# HyNet Carbon Dioxide Pipeline

Written Response Statement on behalf of Peel  
NRE

Planning Inspectorate Reference: EN070007

23 May 2023

DRAWING TITLE  
**Ince - Above Ground Installation (AGI) Drainage Layout**

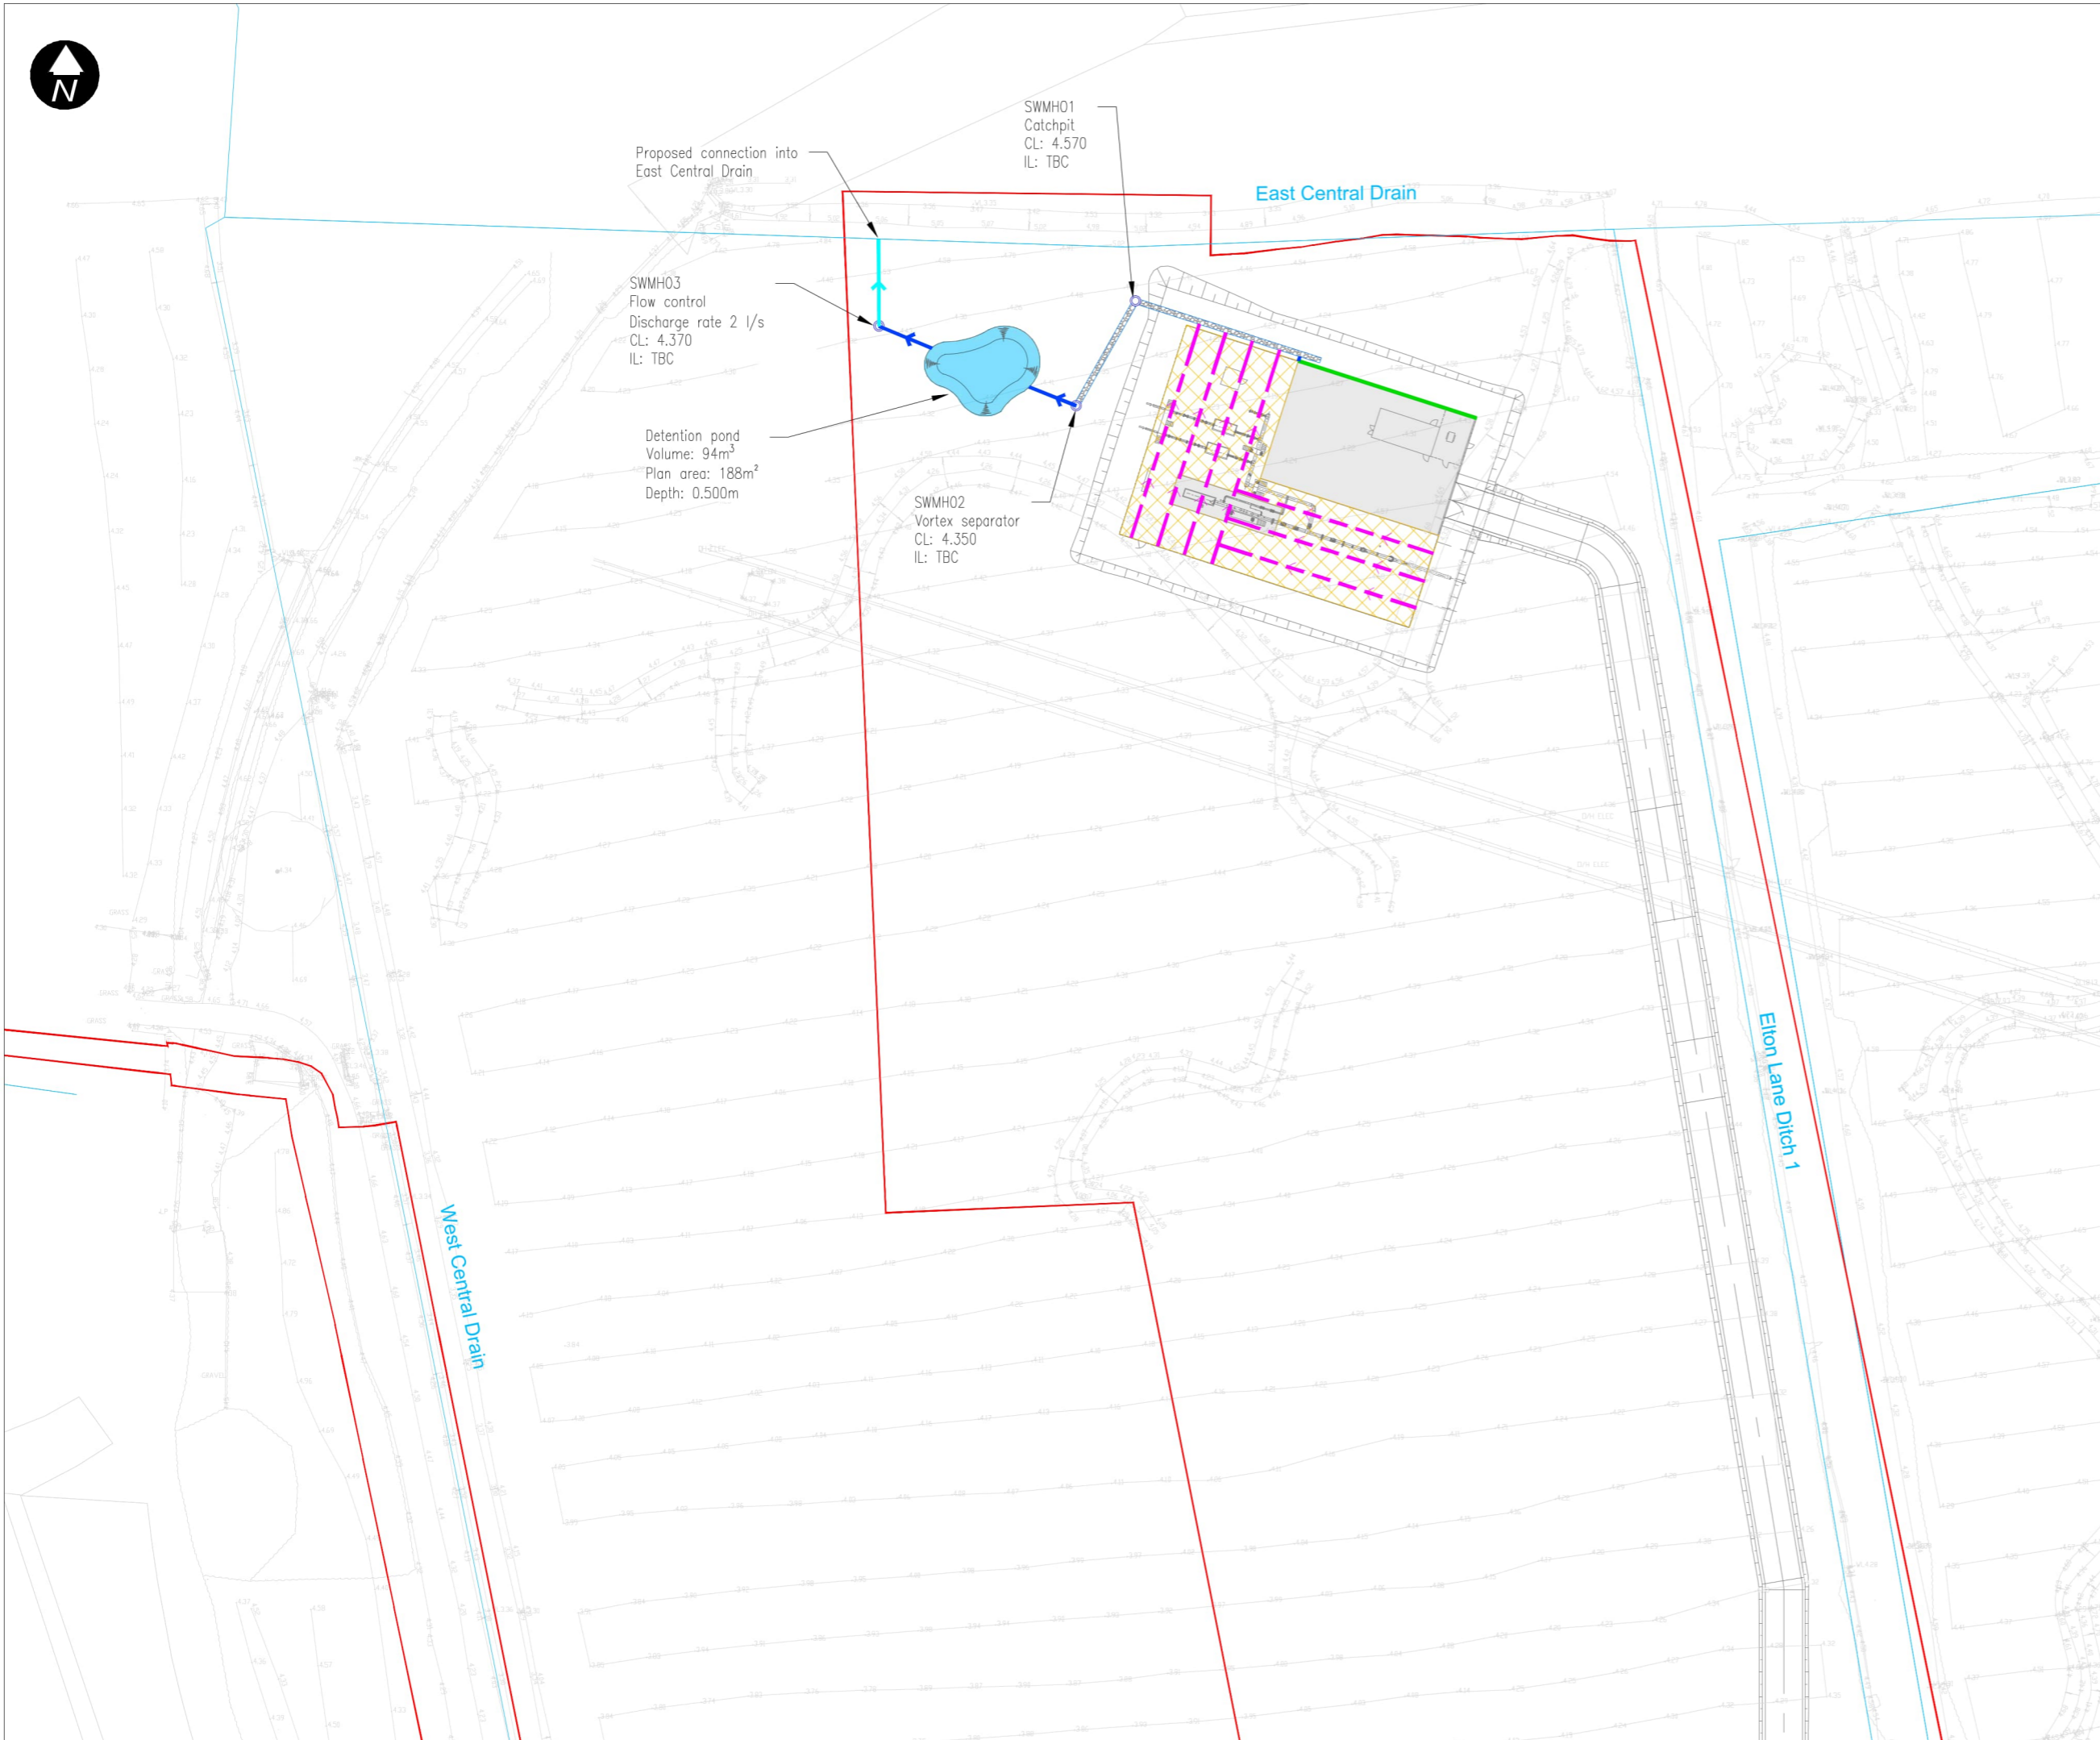
- 2.14 Additionally, the layout of the Ince AGI (as shown on plan ref. EN070007-D.2.10-LAY-Sheet 1 Rev B) orientates the infrastructure to the northwest, adjacent to an existing drain which travels in an east/west direction to the north of the Ince AGI (East Central Drain) (an Environment Agency "main drain"). The Applicant has confirmed that the location of the Ince AGI and associated surface water drainage infrastructure is 8m from the main drain. This infrastructure also needs to incorporate sufficient space for future planned infrastructure within this area and be located to avoid conflict with future development ambitions. On this basis, relocation of the infrastructure to the

east of the Ince AGI should be considered. The surface water treatment will also need to be agreed with the consenting authority.

- 2.18 Additionally, the layout of the Ince AGI (as shown on plan ref. EN070007-D.2.10-LAY-Sheet 1 Rev B) orientates the infrastructure adjacent to an existing drain which travels in an east/west direction to the north of the Ince AGI (East Central Drain). This drain is known for the presence of Water Voles and mitigation is proposed to ameliorate the impacts on these species (see 'Environmental Considerations' below). However, the location of landscaping is not fixed at this stage. This will need to be discussed further with Peel NRE to ensure that this does not prejudice future development ambitions.

- 2.19 Peel NRE accordingly **objects in principle** to the current proposed layout of the Ince AGI and is in the process of discussing matters with the Applicant to agree a position acceptable to both parties. The precise location of the Ince AGI should be agreed with Peel NRE.

Figure 6.1 – Extract of the Ince Park Plastics Masterplan - Drawing Number: 20039-FRA-XX-00-DR-A-90-0005 P2 approved under application no. 21/04076/FUL and works no.3, EN070007-D.2.4-WP-Sheet 1 [AS-012].

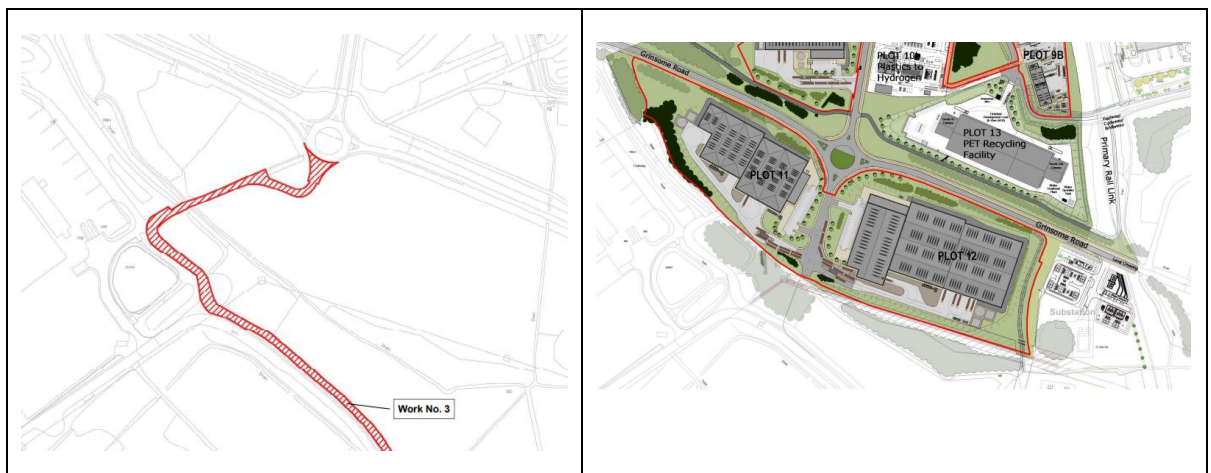
- 2.20 The proposed access has been updated by the Applicant to include Grinsome Road (as shown on Works Plan ref. EN070007-D.2.4-WP-Sheet 1). Additionally, the Applicant's response to the ExA Q1 (Q1.17.3) states they have identified and assessed two routes for use which will mitigate the impact of the construction of the DCO Proposed Development and will not compromise the delivery of the approved Protos Plastics Park.
- 2.21 The updates provided by the Applicant do not address the objections previously raised by Peel NRE and continues to conflict with the delivery of the approved Protos Plastics Park (CWACC Planning application ref. 21/04076/FUL), and the delivery of the railway

line consented as part of the overarching planning permission for Protos (ref. 14/02277/S73), which would constrain the delivery of the developments. Therefore, at this stage, Peel NRE **objects** to the proposed access (as shown on Works Plan ref. EN070007-D.2.4-WP-Sheet 1).

- 2.22 A plan of the approved Plastics Park masterplan (ref. 20039-FRA-XX-00-DR-A-90-0005 P2) is provided with an overlay of the proposed access route to the Ince AGI and pipeline (shown on plan ref. EN070007-D.2.4-WP-Sheet 1). This is provided at Figure 1 (and at Appendix 16 to the Written Representations (17 April 2023)). This overlay plan clearly shows the conflict of the Applicant's proposed access with the planned development of the Plastics Park at Protos.

DRAWING TITLE
 Figure 19.1 Other Developments Sheet 1 of 3

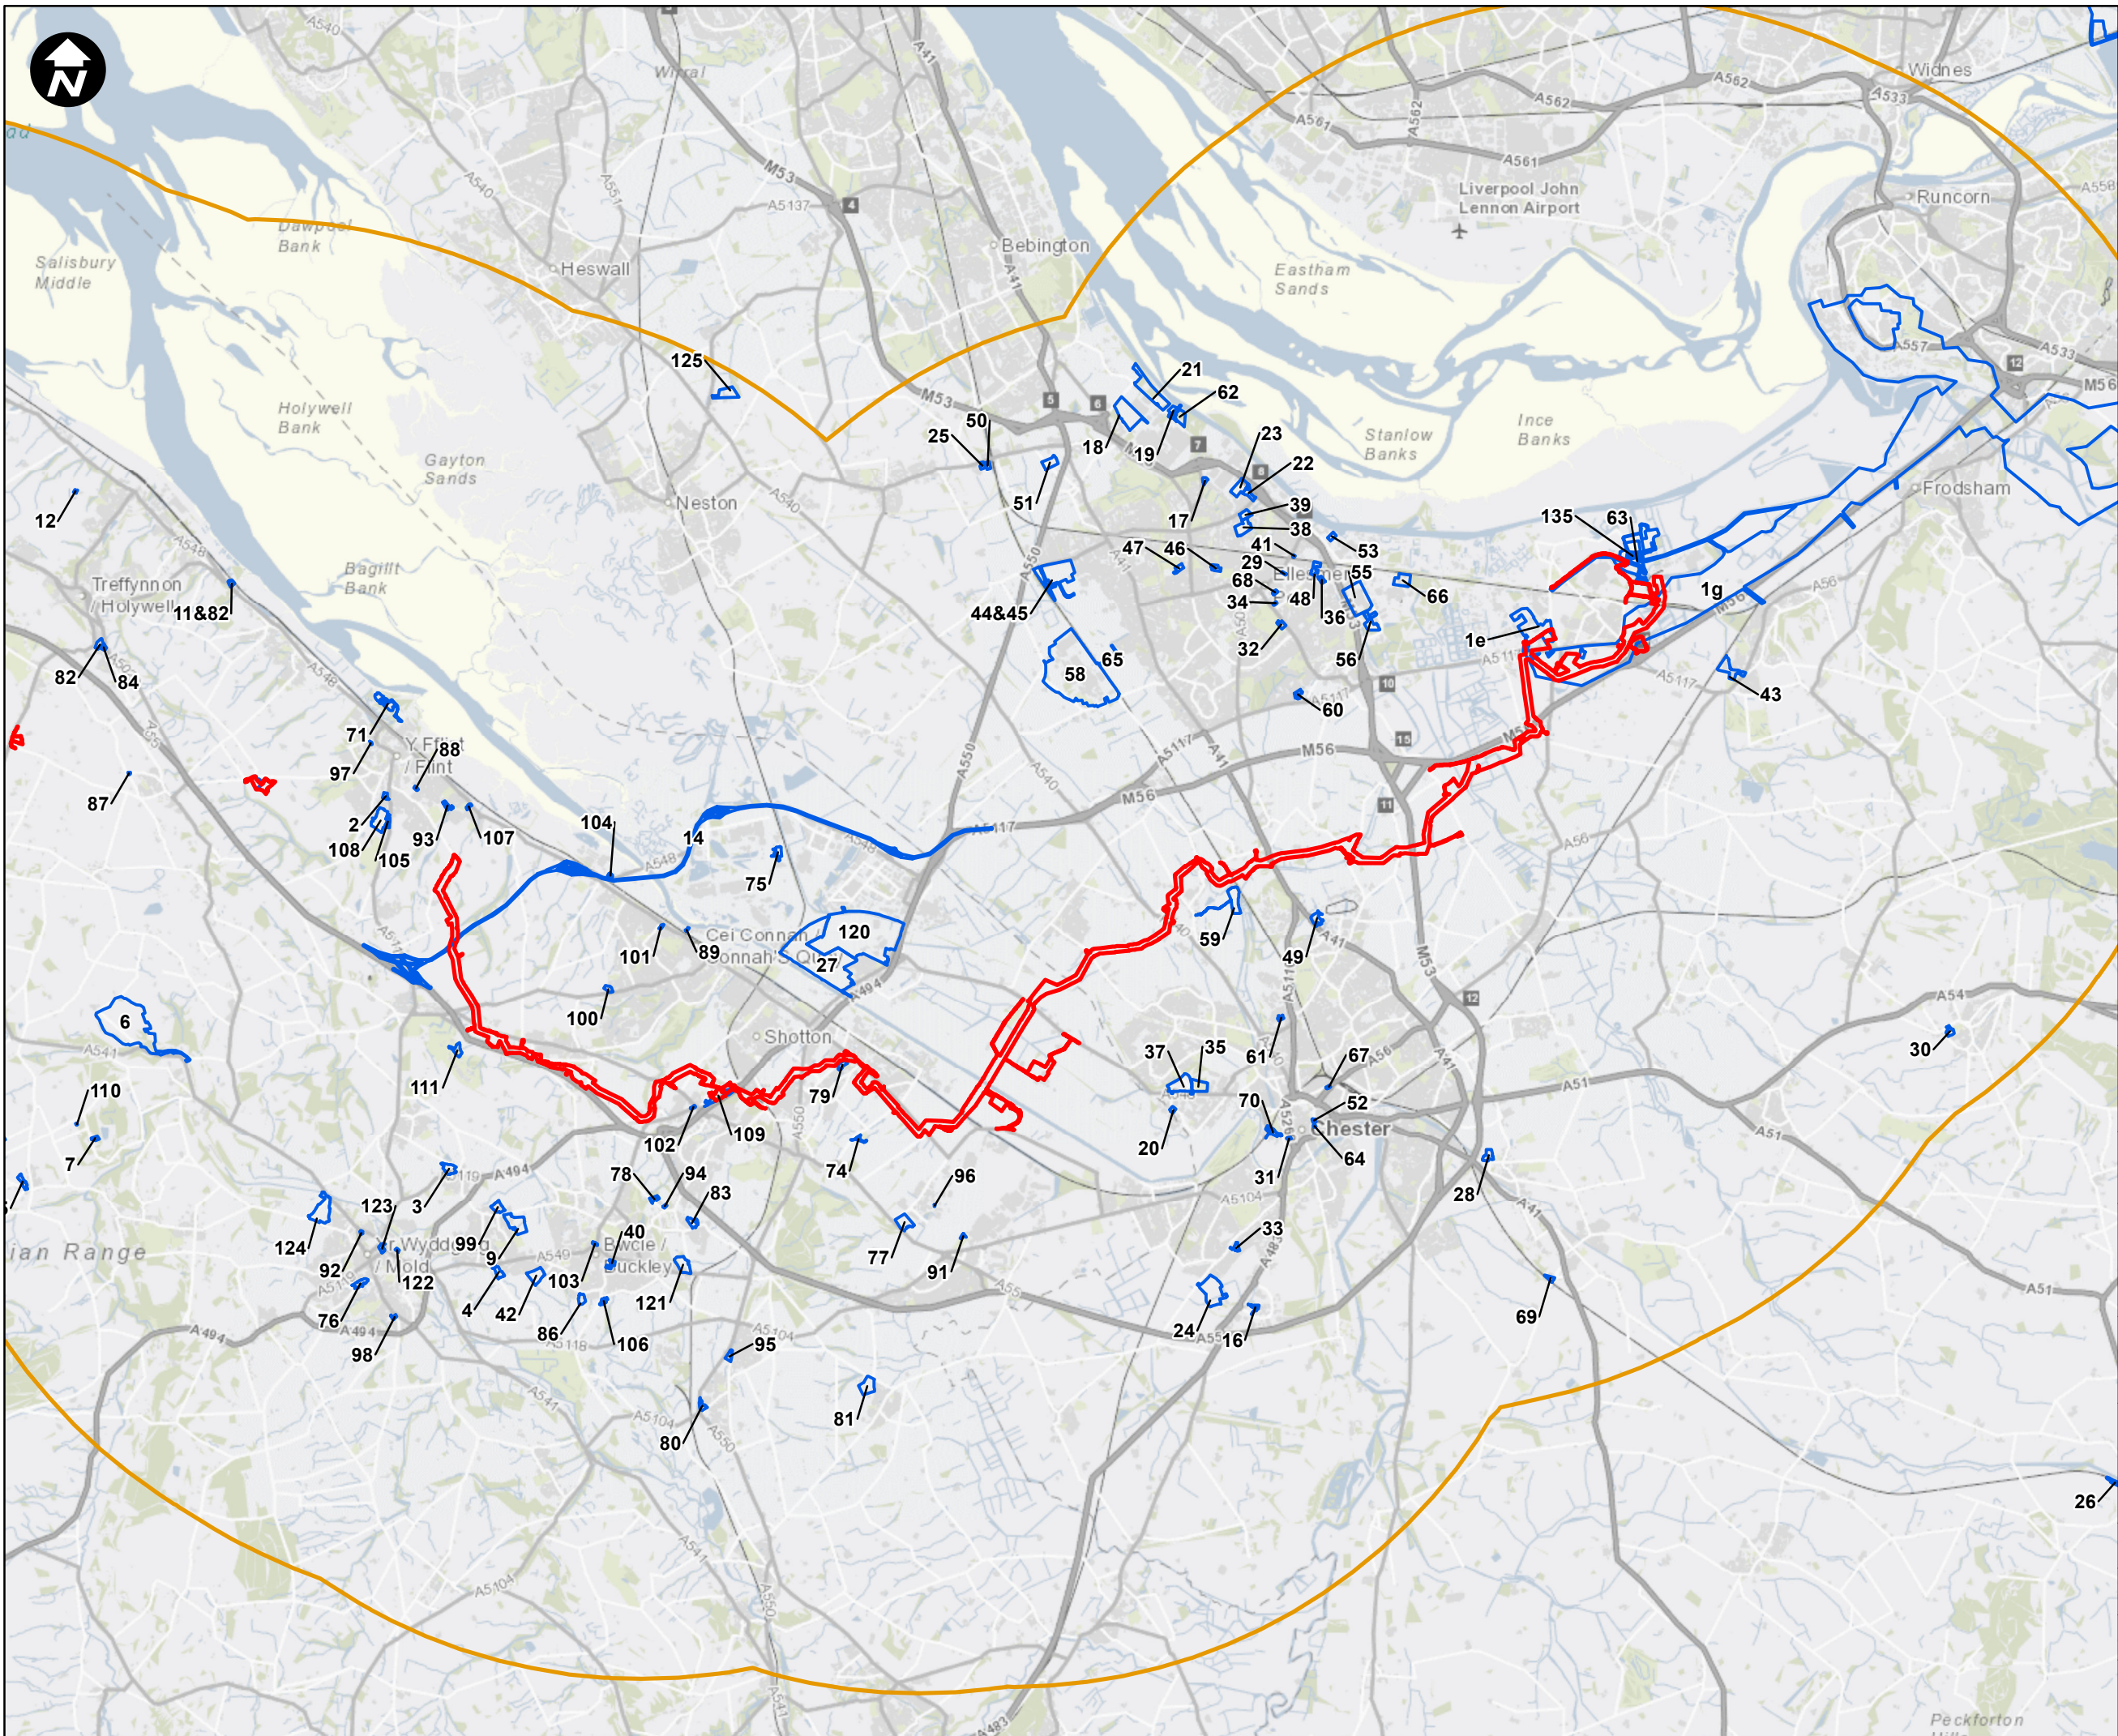
- 2.41 To identify relevant projects for the assessment of inter-project effects, a series of search criteria have been used (Chapter 19, Paragraph 19.5.14). Based on the search undertaken three projects have been identified within Protos (Appendix 19.1 (Table 2) and Figure 19.1), comprising:

- ID 63 TCPA - CWACC Reference: 20/04396/FUL: Resource recovery facility (Plastics Recycling Facility).
- 2.42 Whilst these Other Developments have been considered, there are a number of other extant permissions which have not yet been implemented or are under construction as of Spring 2023 which lie within the land owned by Peel at Protos. These are outlined in **Appendix 2**. The location of these developments is provided at **Appendix 4**, and layout plans at Appendices 5 – 15.

- 2.43 Due to the proximity and scale of these developments and potential for intra-project effects due to the presence of common sensitive environmental receptors (specifically in respect to landscape and visual, air quality, traffic and transport and biodiversity), Peel NRE **objects** to the current scope and contents of the cumulative assessment. It is

understood that an updated cumulative assessment will be prepared as part of an update ES during the examination.
